# Sign Plan\_V2.pdf Markup Summary

# VENETUCCI FARMS

A PORTION OF THE SW  $\frac{1}{4}$  OF THE SW  $\frac{1}{4}$  OF SECTION 11 AND A PORTION OF THE NW  $\frac{1}{4}$  OF SECTION 14, EL PASO, COUNTY  
 5202 HWY 85-87, 5210 HWY 85-87, 5304 HWY 85-87 & 5304 HWY 85  
 SPECIAL USE PERMIT - BUSINESS EVENT CENTER

**SIGN PLAN**

# VENETUCCI FARMS

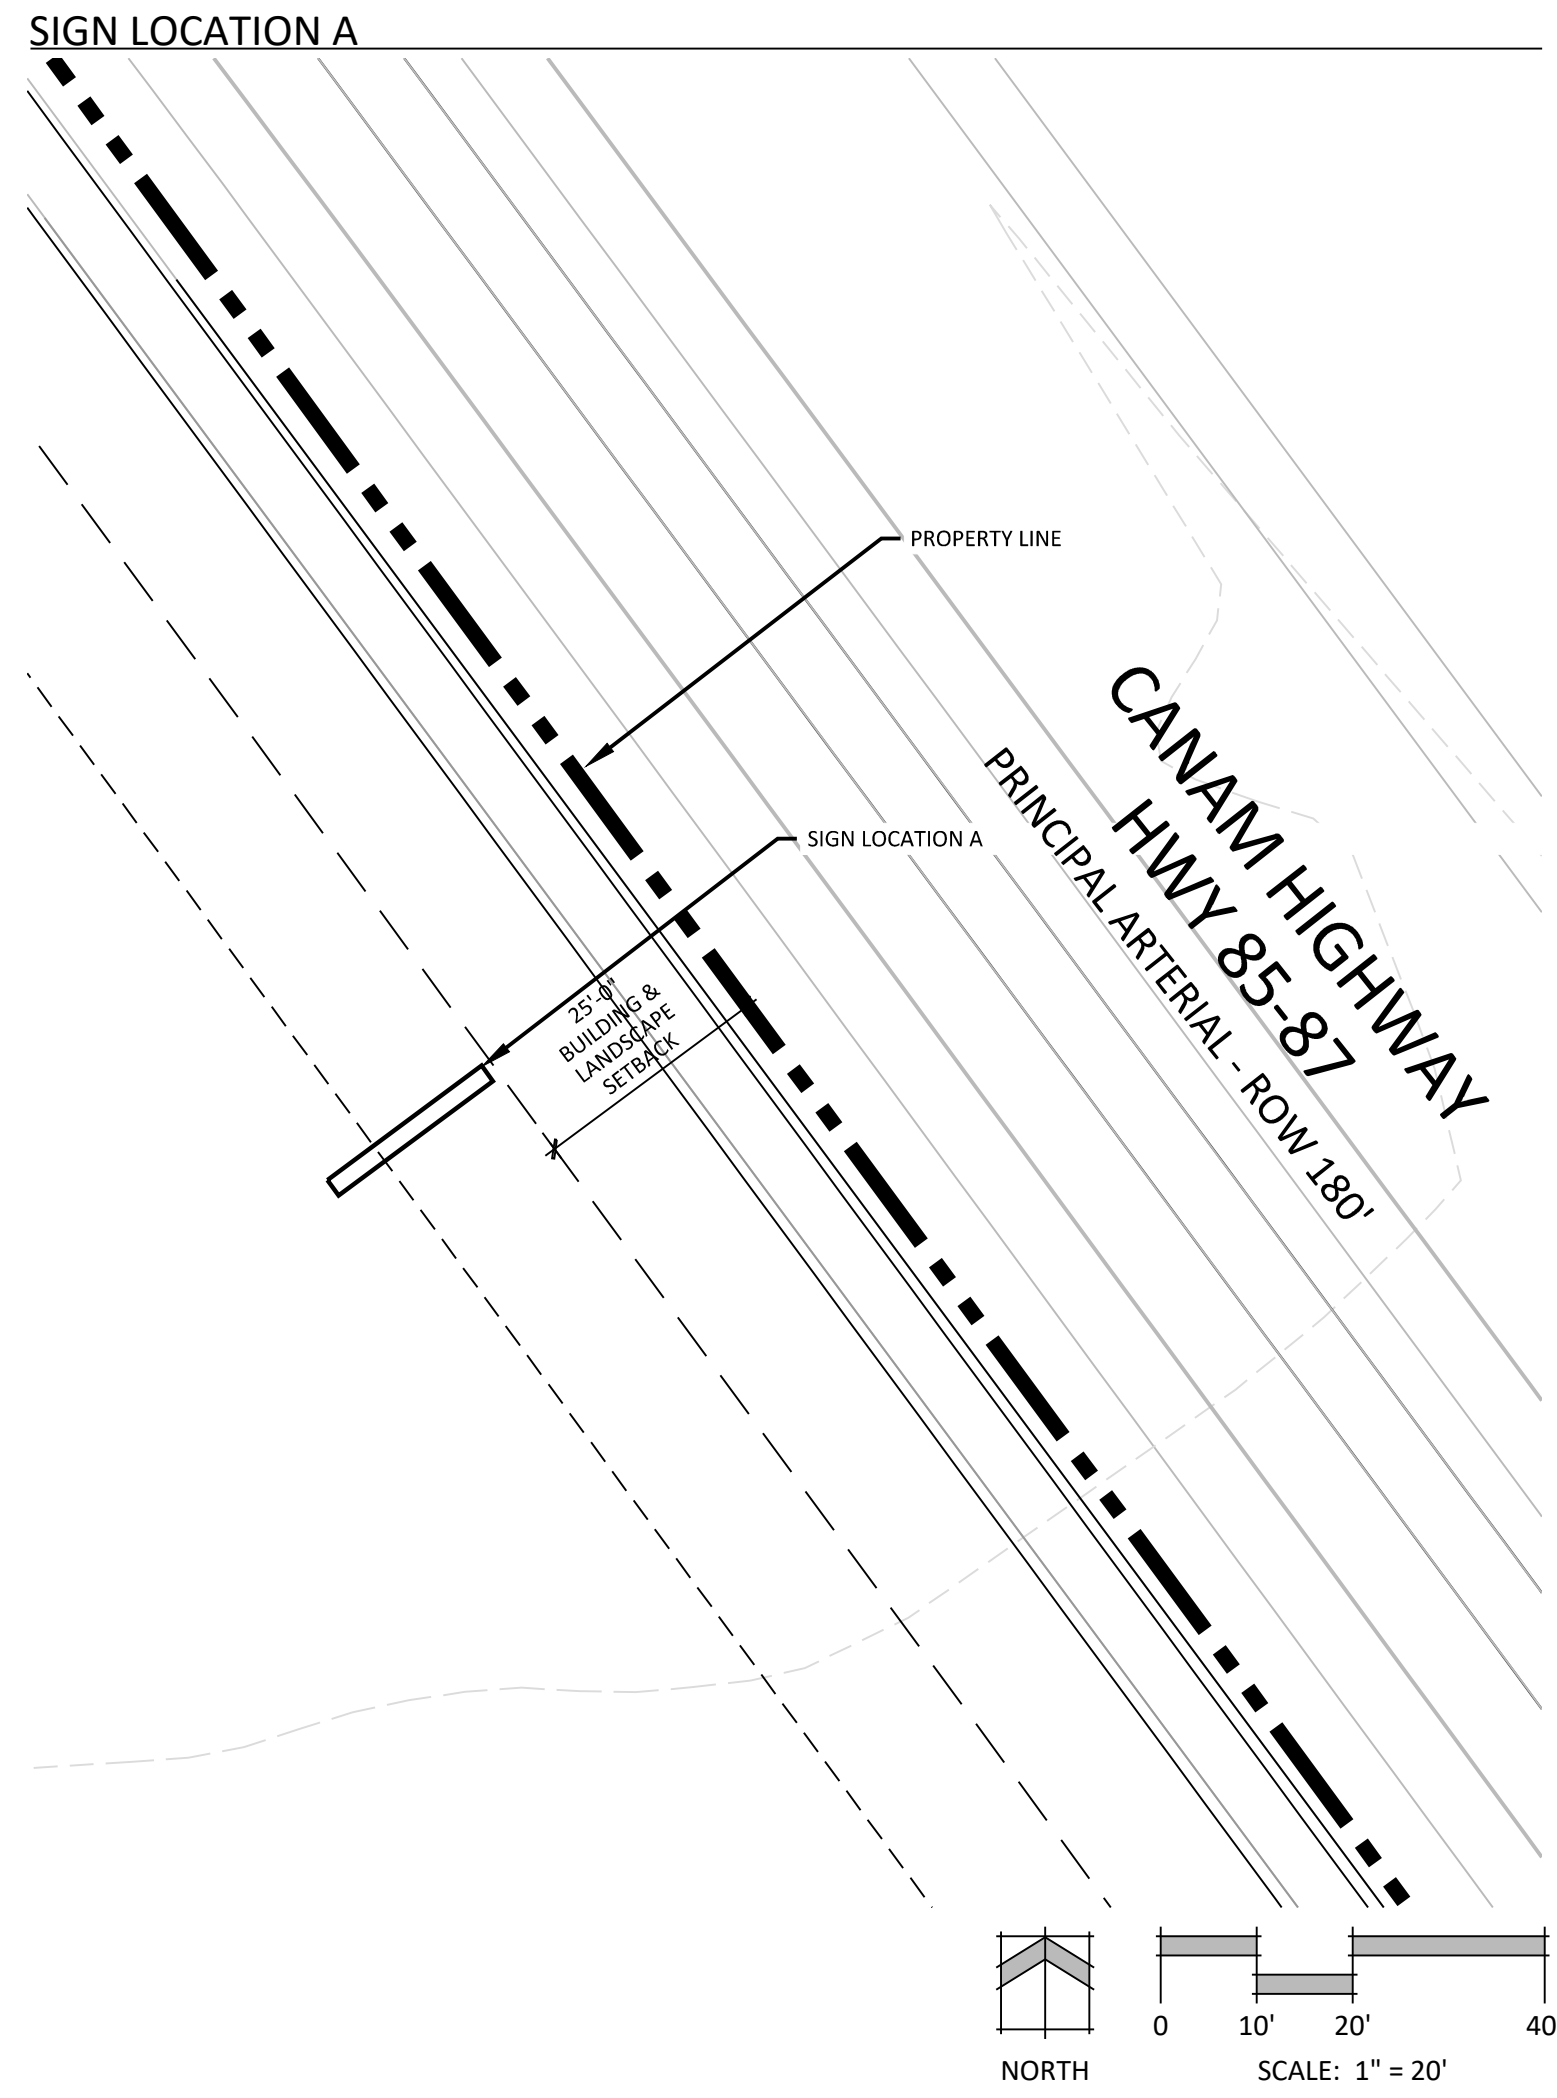
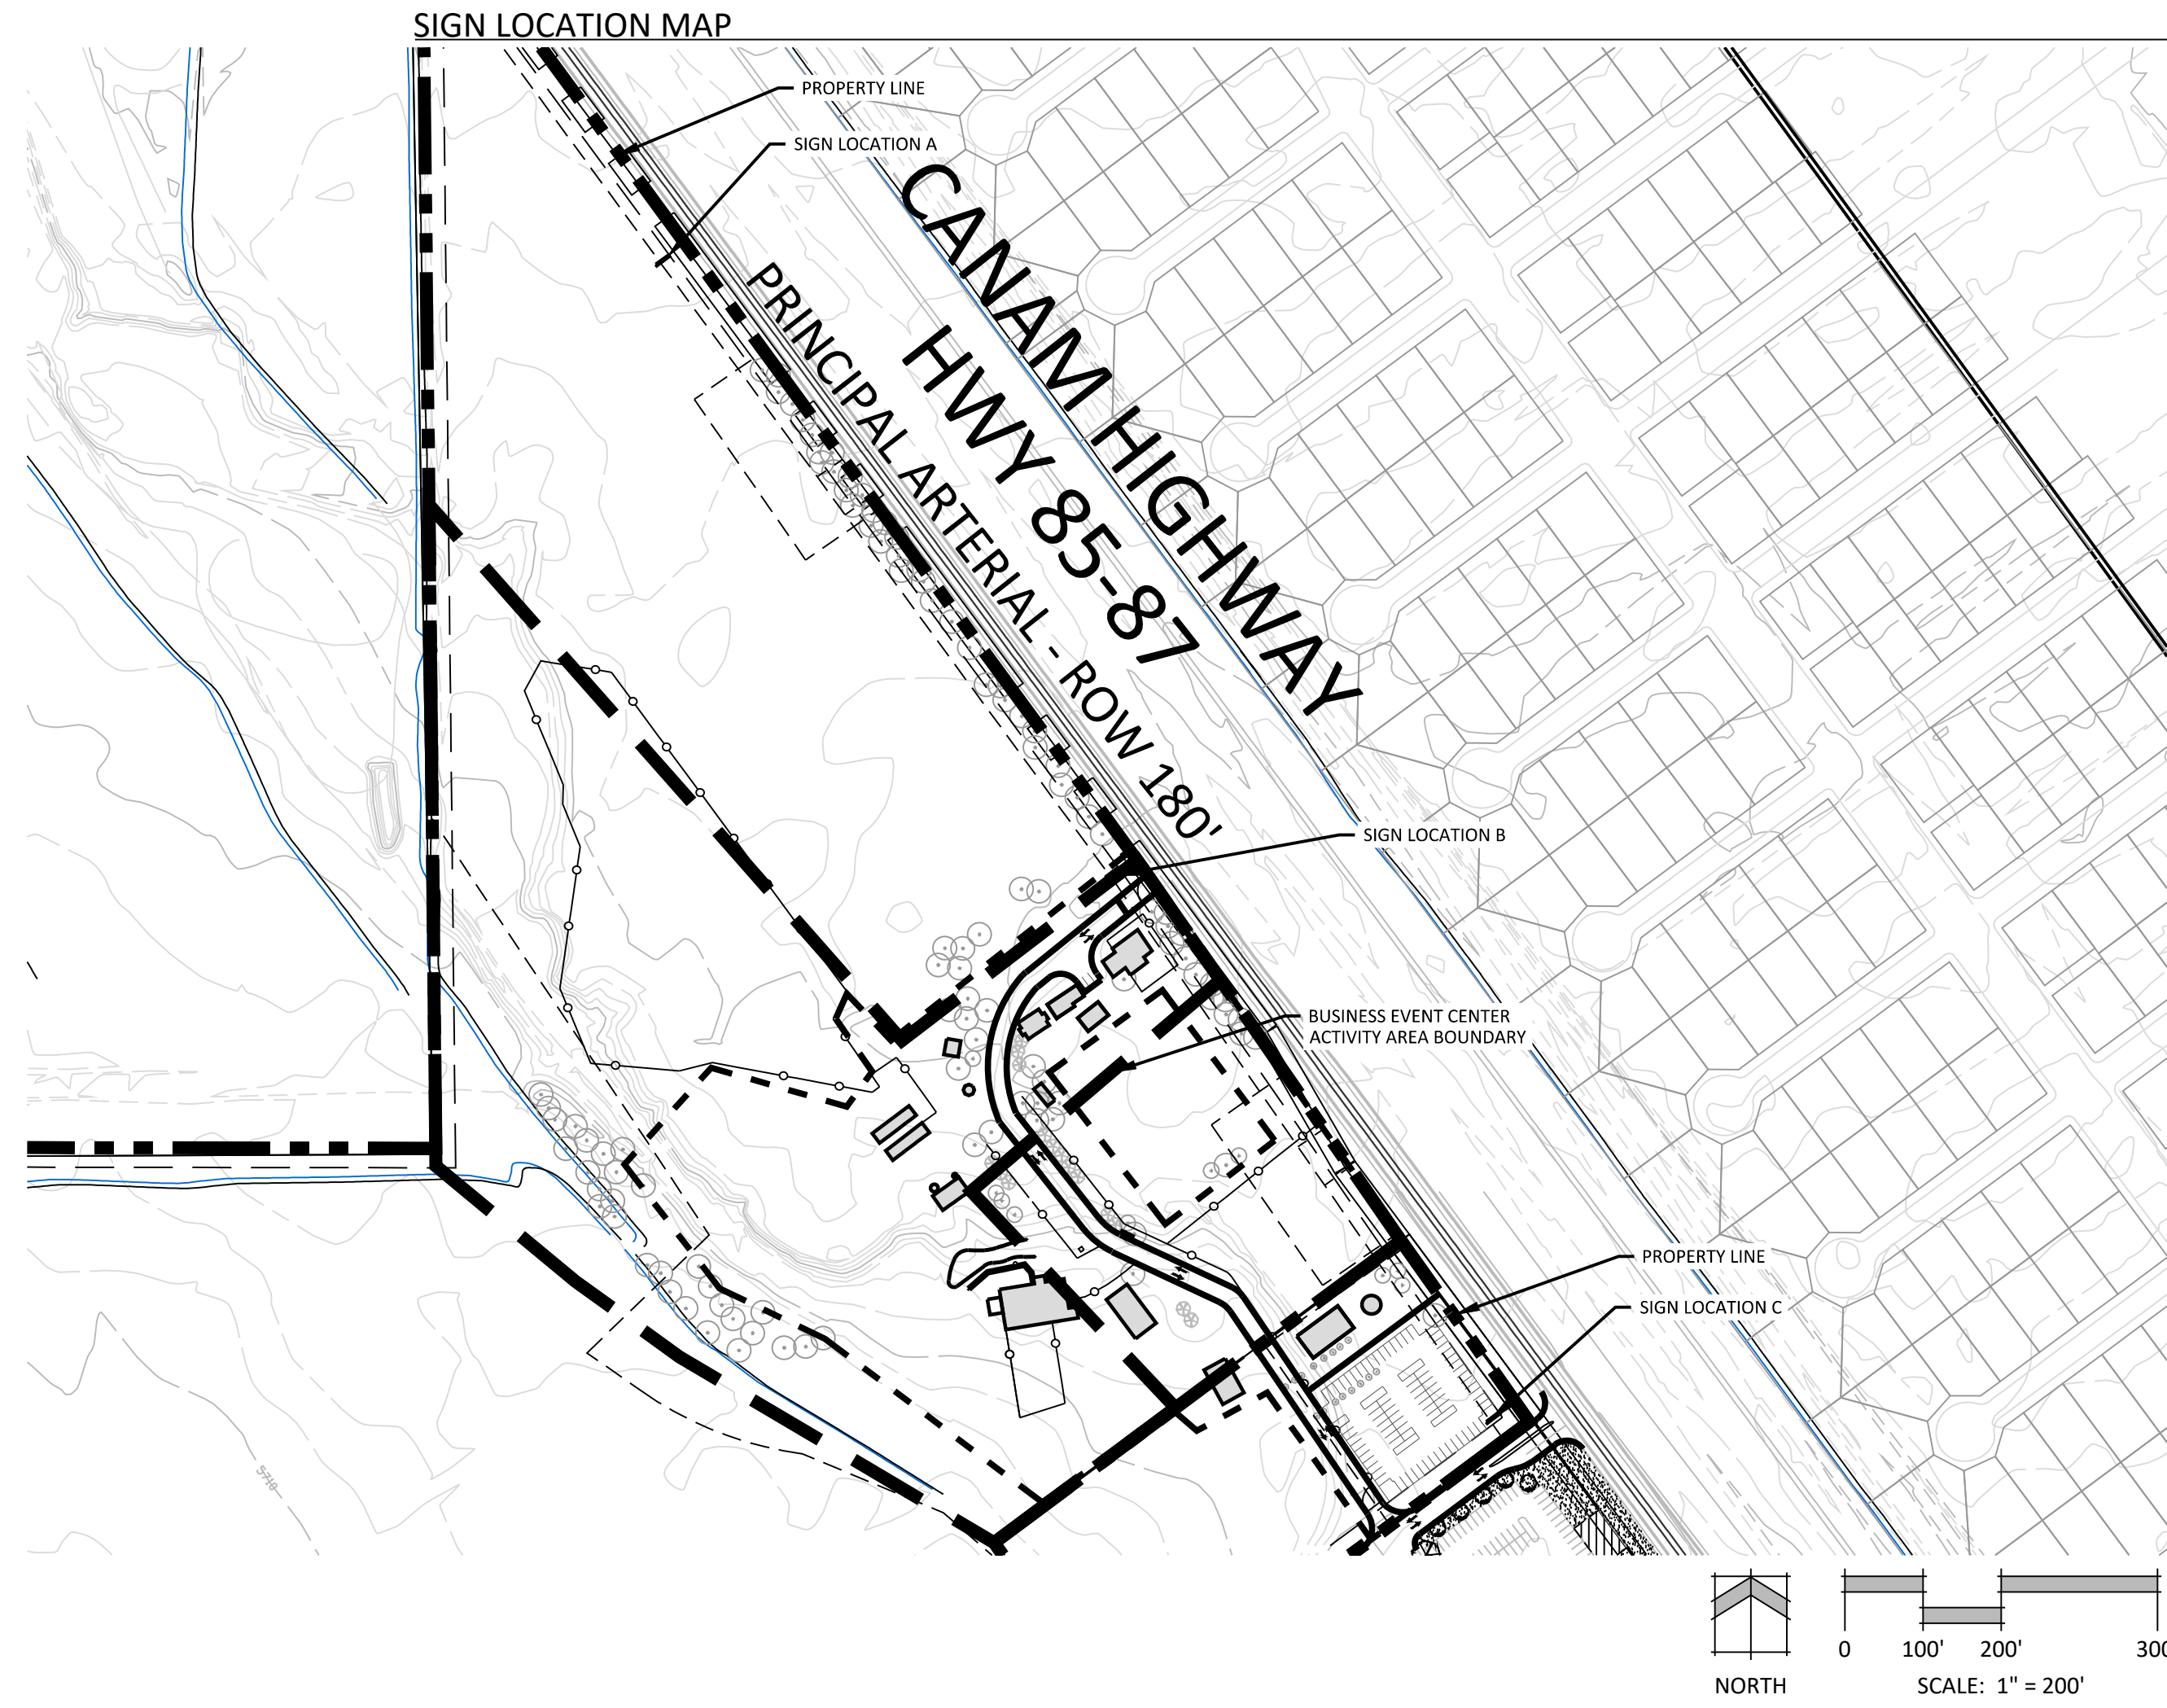
Include summary of square footage of the total allowed signage and existing and proposed signage for the property
